APPLICANT'S RESPONSE TO INTERESTED PARTIES' DEADLINE 4 SUBMISSIONS: 9.27

Cory Decarbonisation Project

PINS Reference: EN010128

March 2025

**Appendix 10-4  
Visual Assessment Photomontages - Winter**

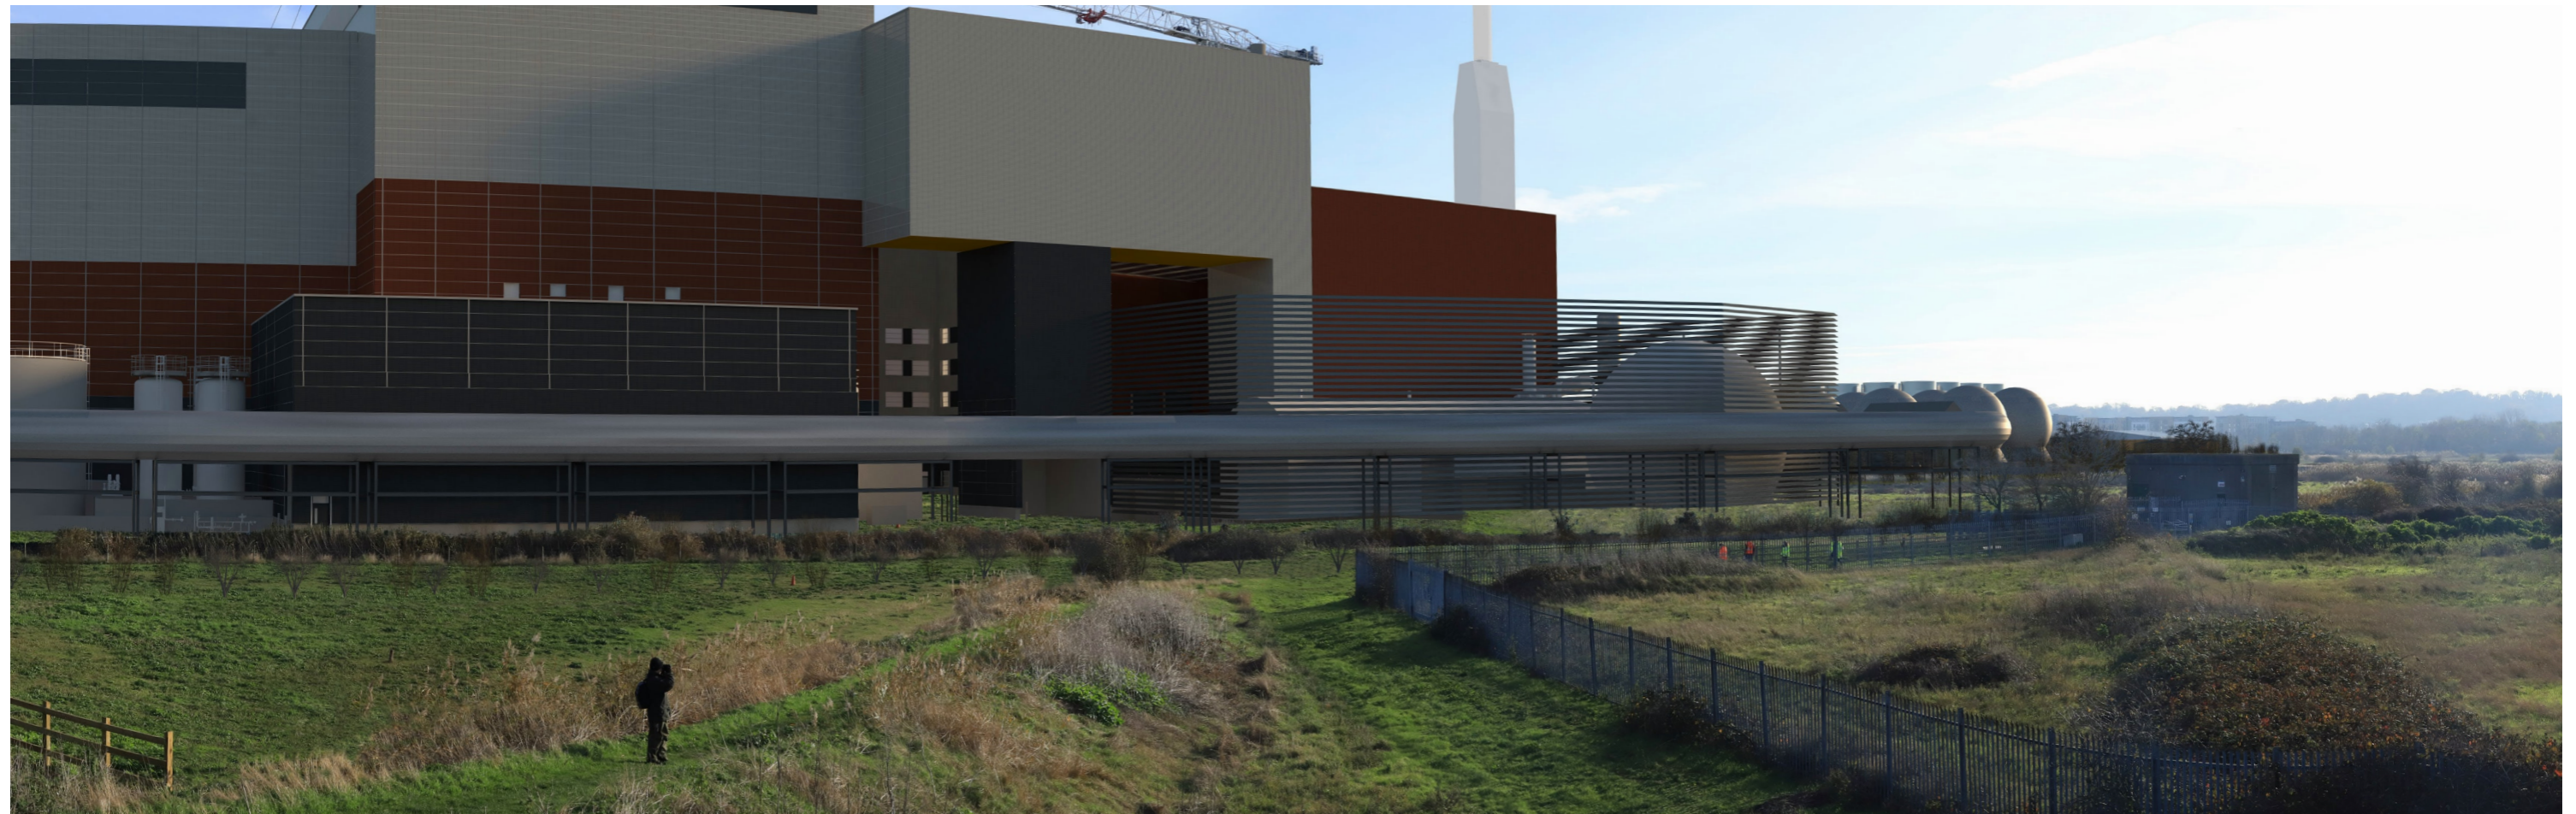
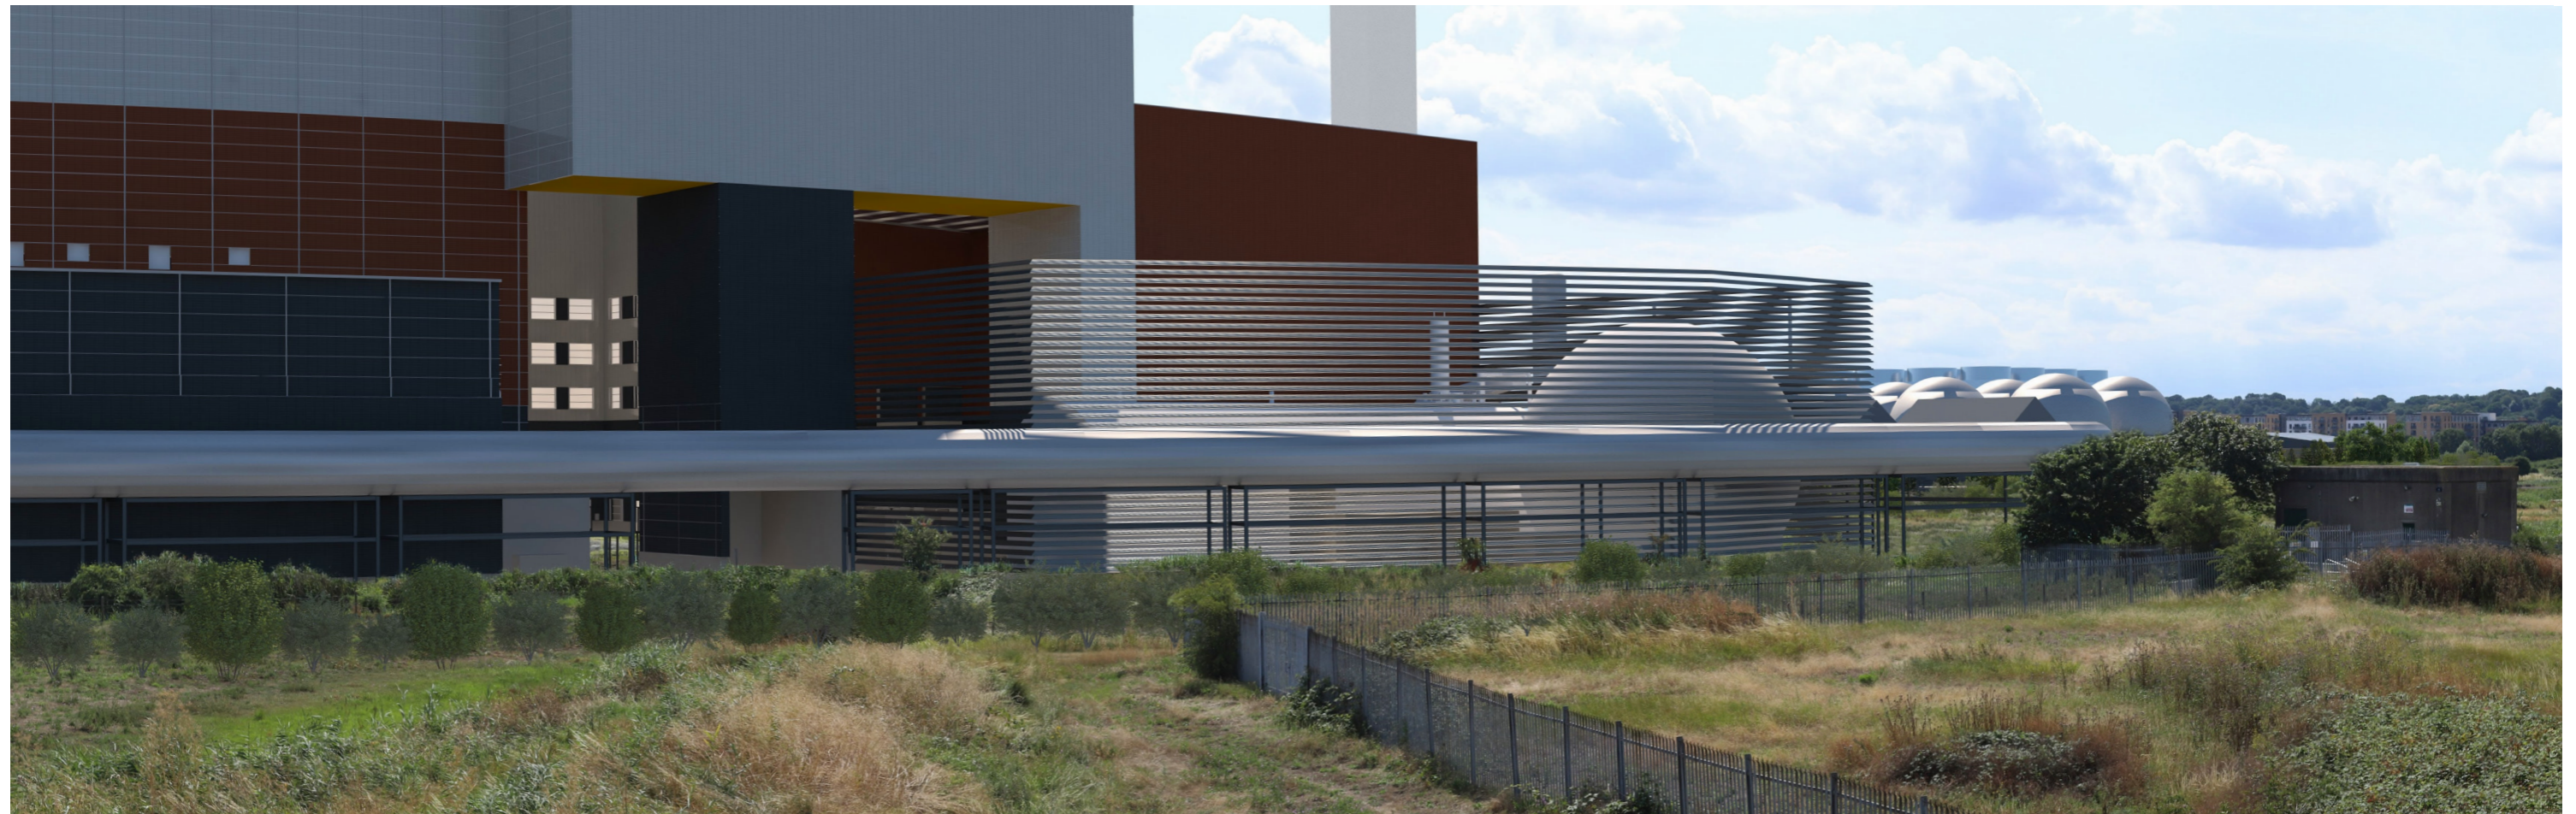
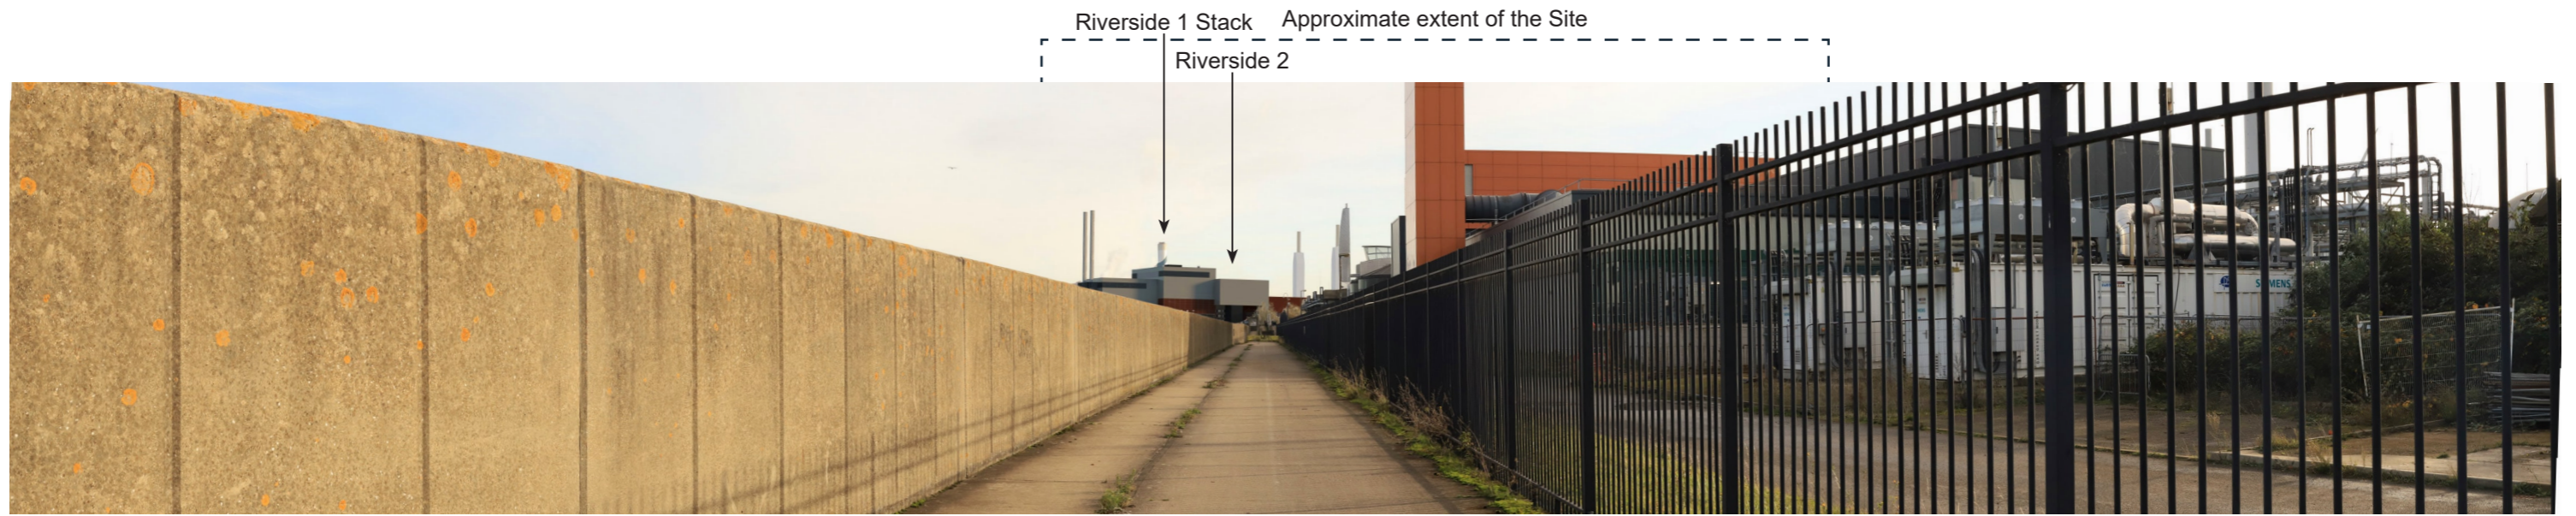
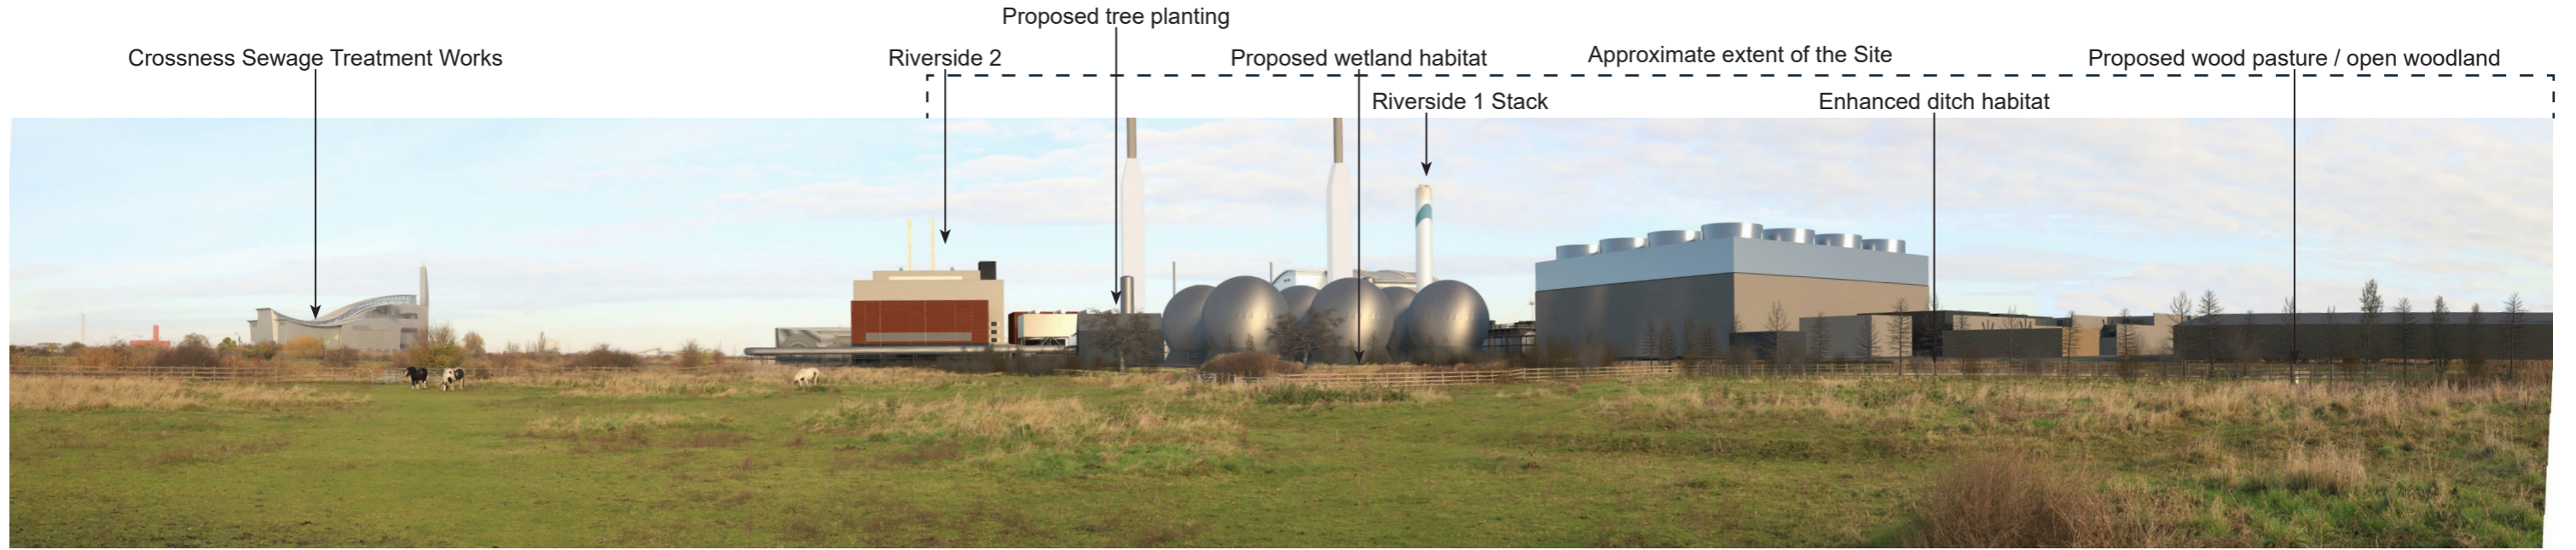
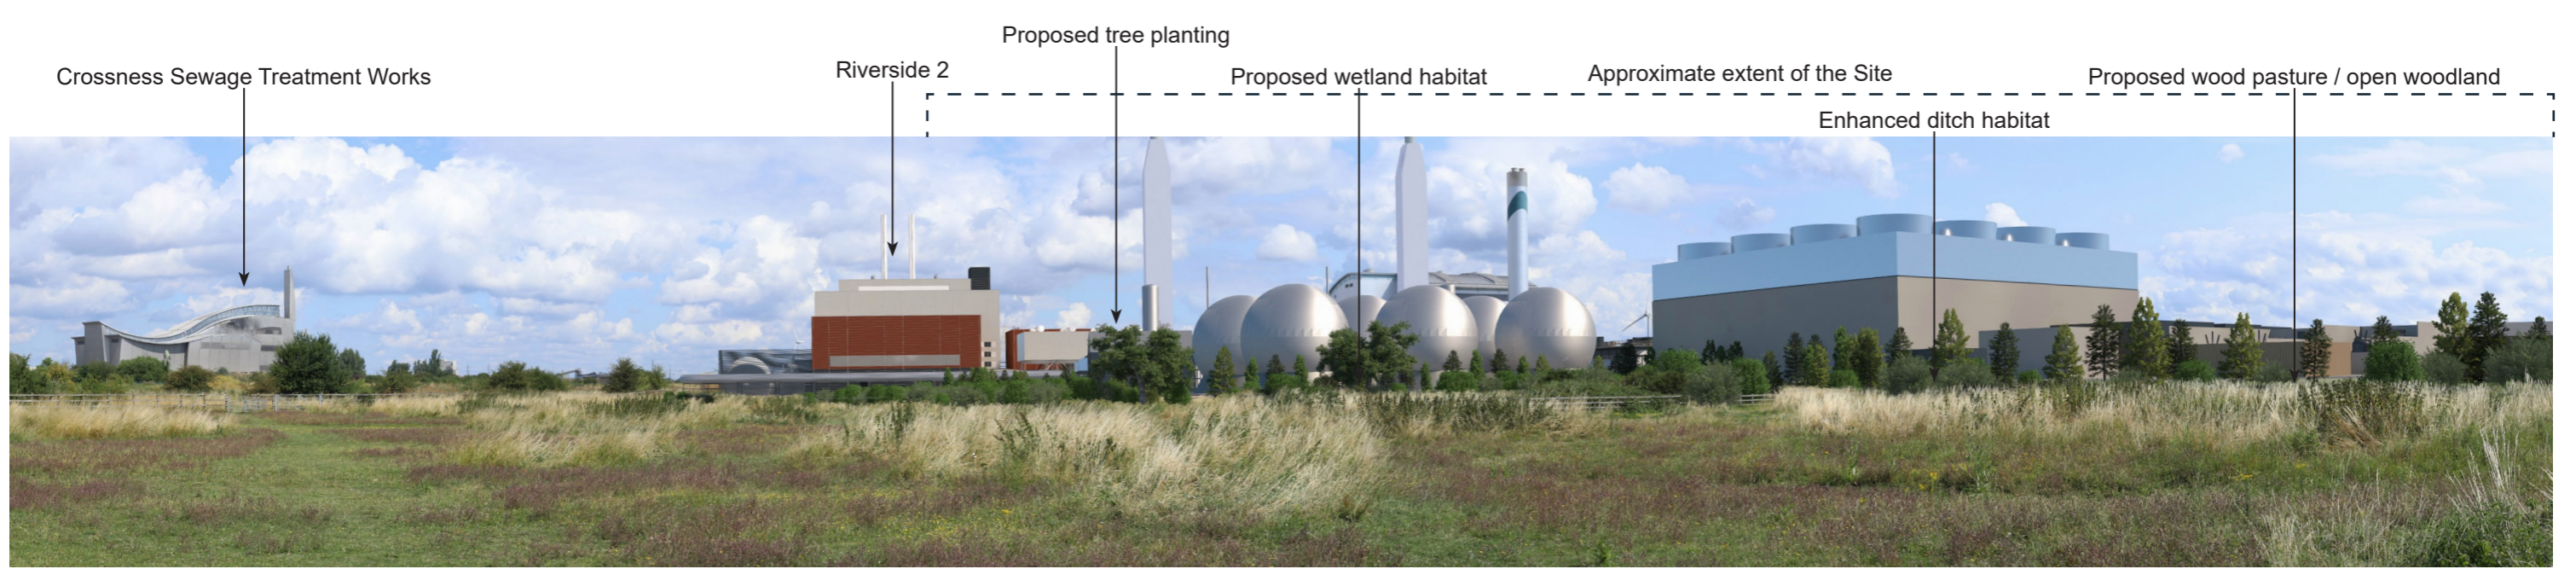
Design		
2.6.3	<p><u>Visual impact - photomontages</u></p> <p>8. As raised during the Accompanied Site Visit, we are concerned that the Photomontages do not depict the full visual impact on Crossness Nature Reserve. There is no view showing the full north-south stretch of the Proposed Scheme from Crossness Nature Reserve. 'Sequential View 1' is largely obscured by Riverside 2. 'View 1' shows the Proposed Scheme from FP2 looking north, where the impact is less severe: REP1 and REP2 are already in the sightline, and you do not see the crosssection of the full north-south length of the Proposed Scheme.</p> <p>9. We request that the Applicant provide an additional view from the entrance to the Member's Area (at the end of the access road and along the north-south path along the western edge of the main Crossness Nature Reserve area), so that the visual impact of the full north-south length of the Proposed Scheme can be assessed. This would also give a close representation of the view from the bird hide, which is particularly sensitive to visual impact.</p>	<p>Please see the Applicant's response to the ExA's question 2.18.1, also submitted at Deadline 5.</p>
